J.S. THOMPSON
ENGINEERING, INC

December 19, 2024

The "Avery" plan, truss layouts and drawings provided by Comtech were reviewed for 22 Peach Orchard Lane in Lillington, North Carolina to address the differences between the sealed plan and roof truss layouts as noted by the inspector.

ROOF & FLOOR TRUSSES & BEAMS

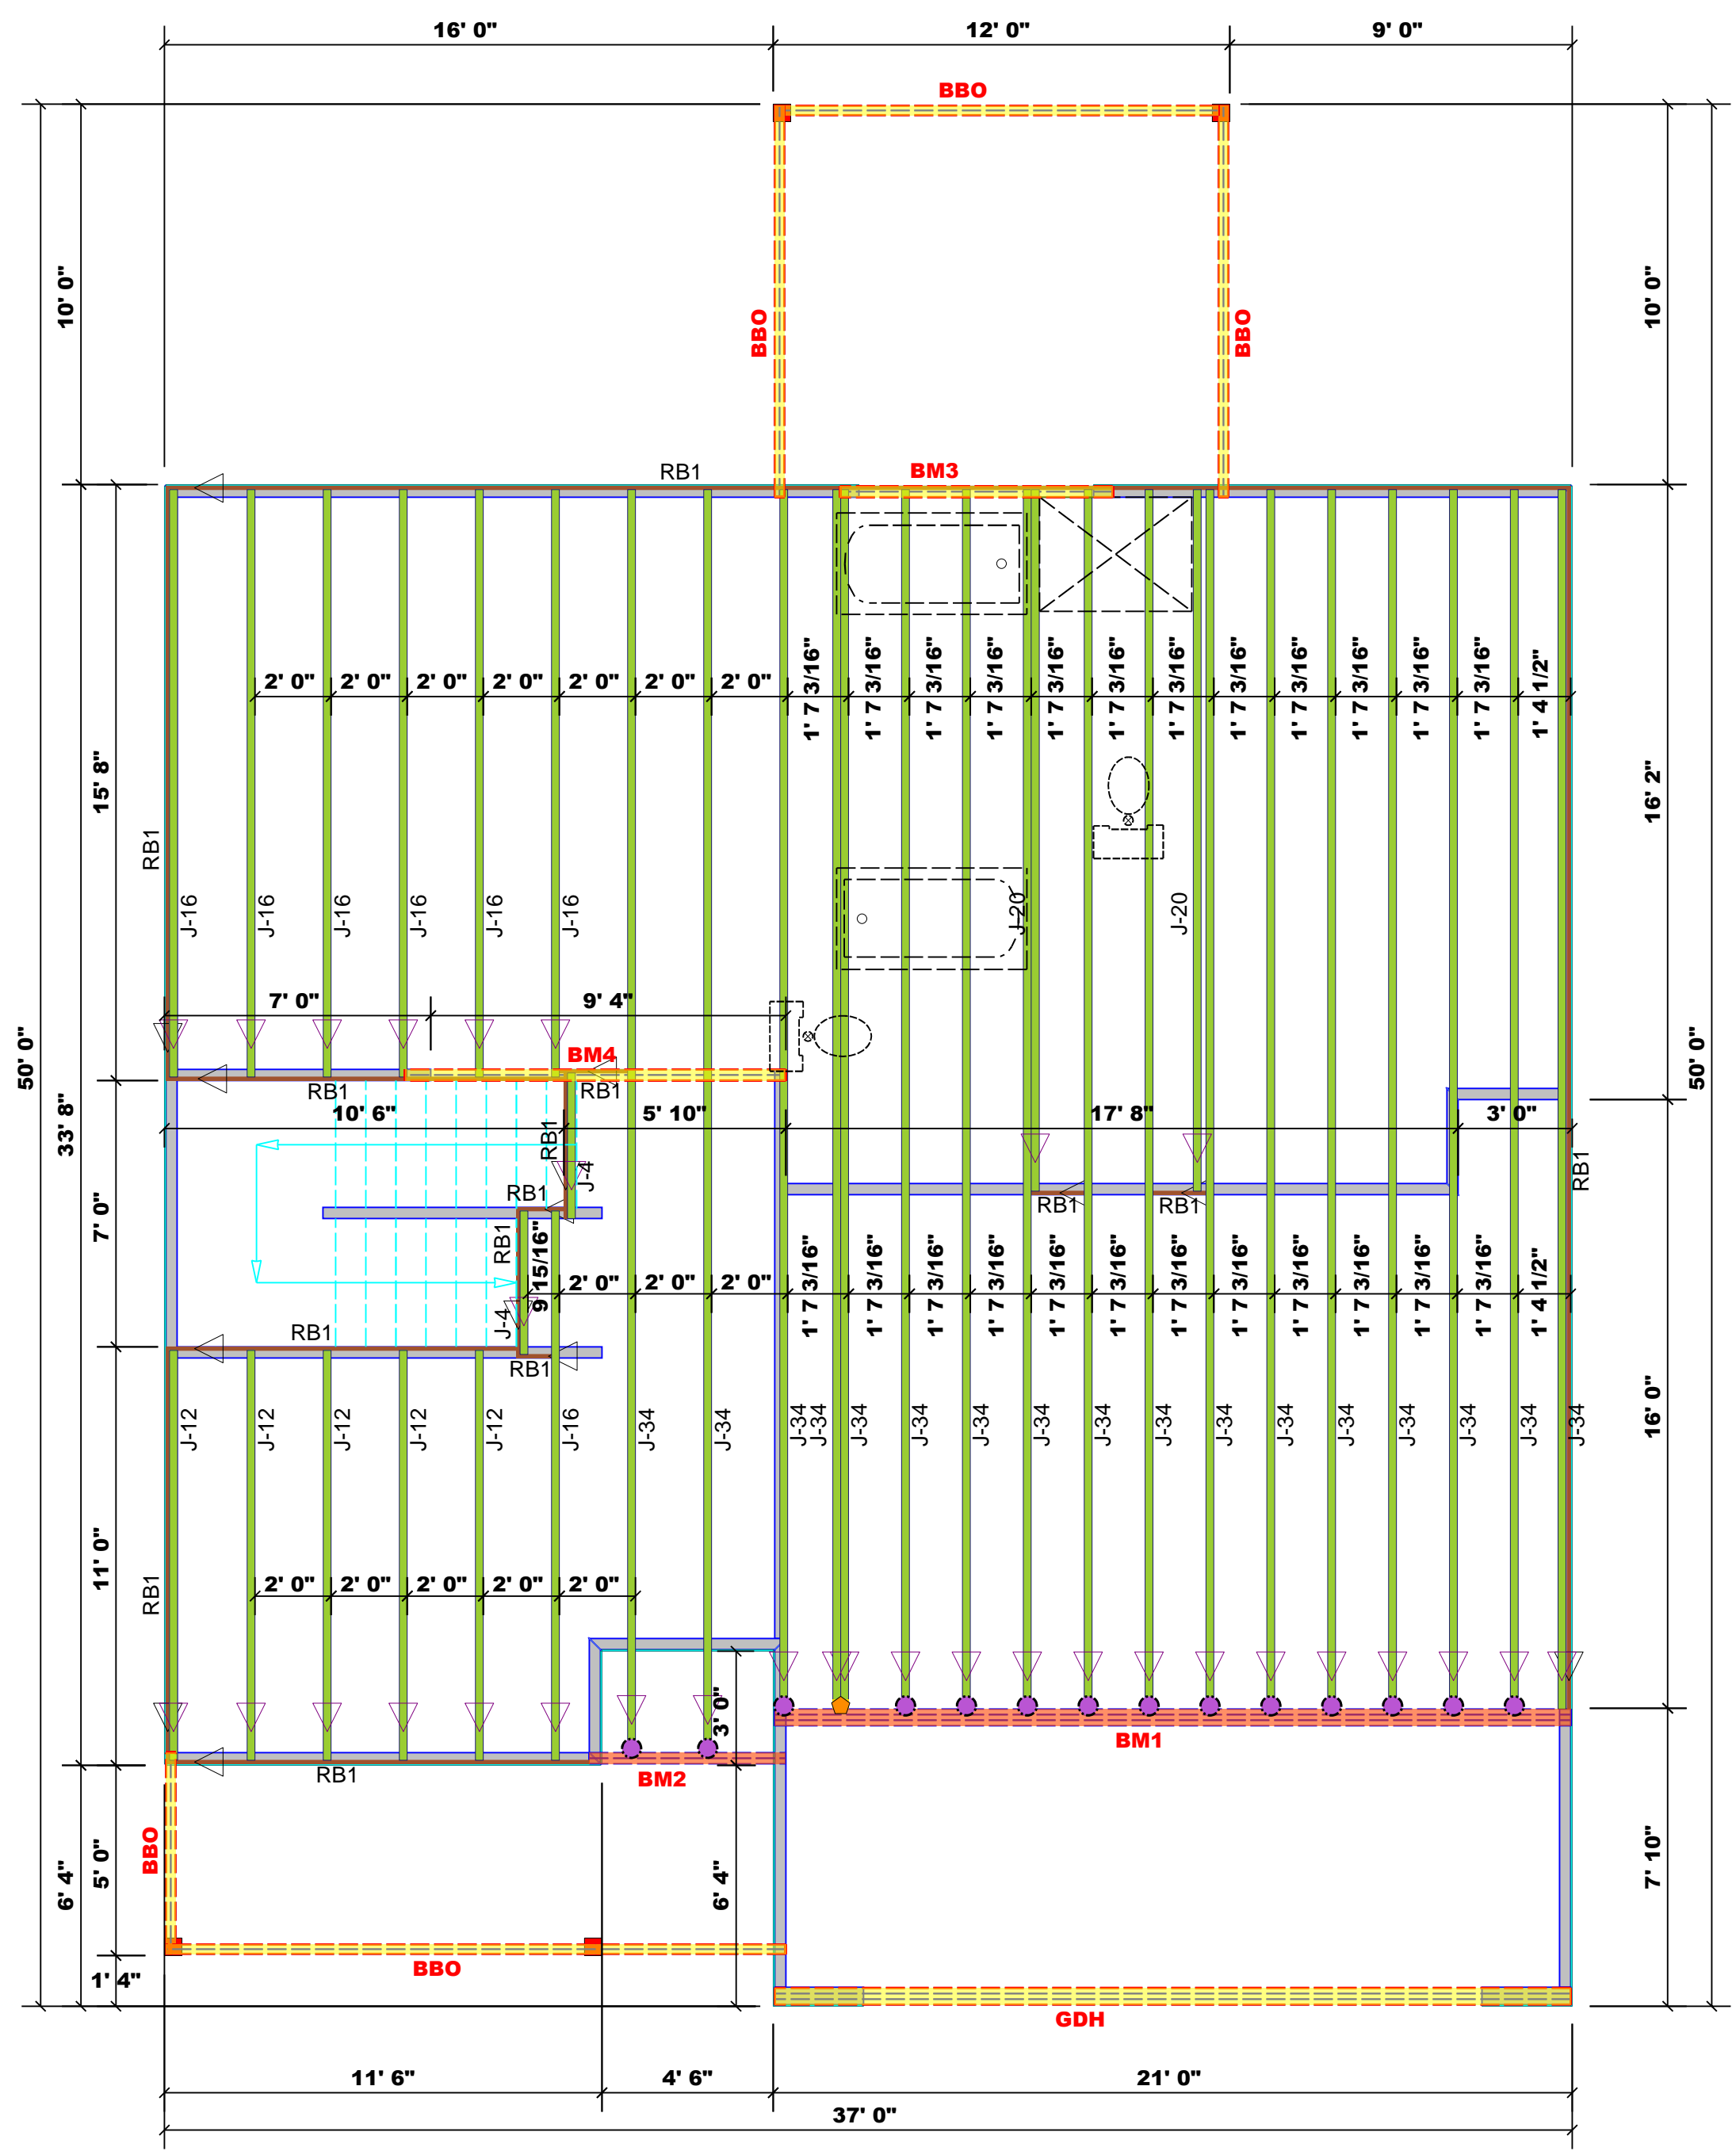
The roof layout was modified to remove the truss bearing walls on either side of the second floor hallway and to remove the front to back girder truss in order for trusses to bear on the bedroom #4 wall. An LVL was added above the hallway to support the girder truss above the stairs. Analysis revealed the following:

- 1) The front to back girder truss is not required. The (2) 1 3/4" x 9 1/4" LVL above the hallway is sufficient to support the applied loads from the girder truss above the stairs. Install (3) 2 x 4 at each end of the LVL and block solid to the foundation.
- 2) A minimum (2) 2 x 6 header with (1) jack and (1) king stud is required at the new load bearing laundry closet wall. Block the point loads solid to the foundation
- 3) There will be no offset load or point loads to support within the joists above the garage.

This configuration will provide the required support for all applied loads.
